From: Fiona Fitzgerald
Sent: 08 June 2015 10:25
To: Planning.Responses; Anita Gardner
Subject: A/50/15/PL

Drawing
Proposed Elevations
New Annexe Building

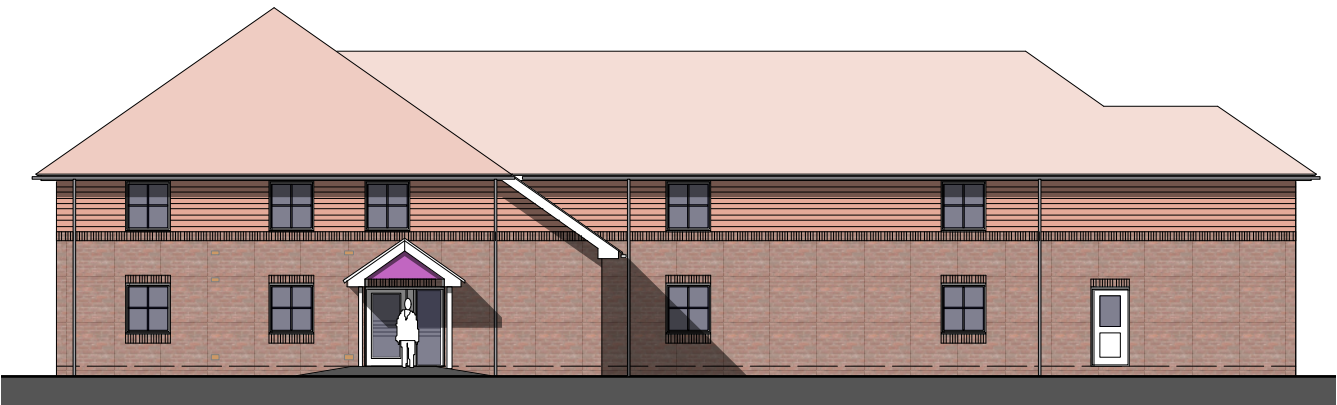
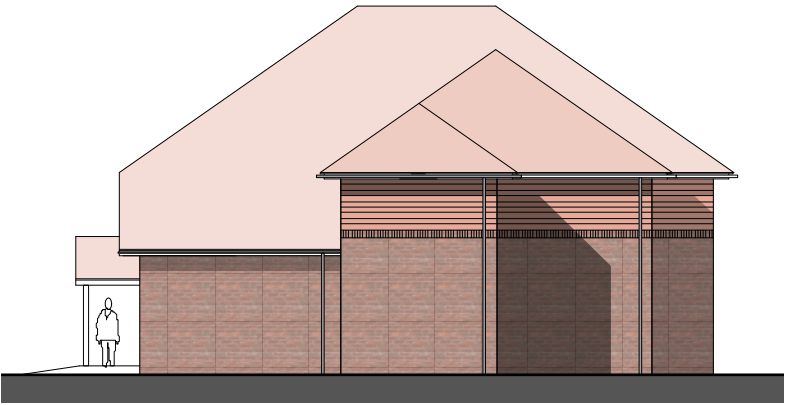
Please could you ask the applicant to forward details of any external units to be installed on the exterior of the new annex –air conditioning/heating installations. Please ask them to include details of the location, number, and assessment of any noise impact on the nearest noise sensitive neighbours.
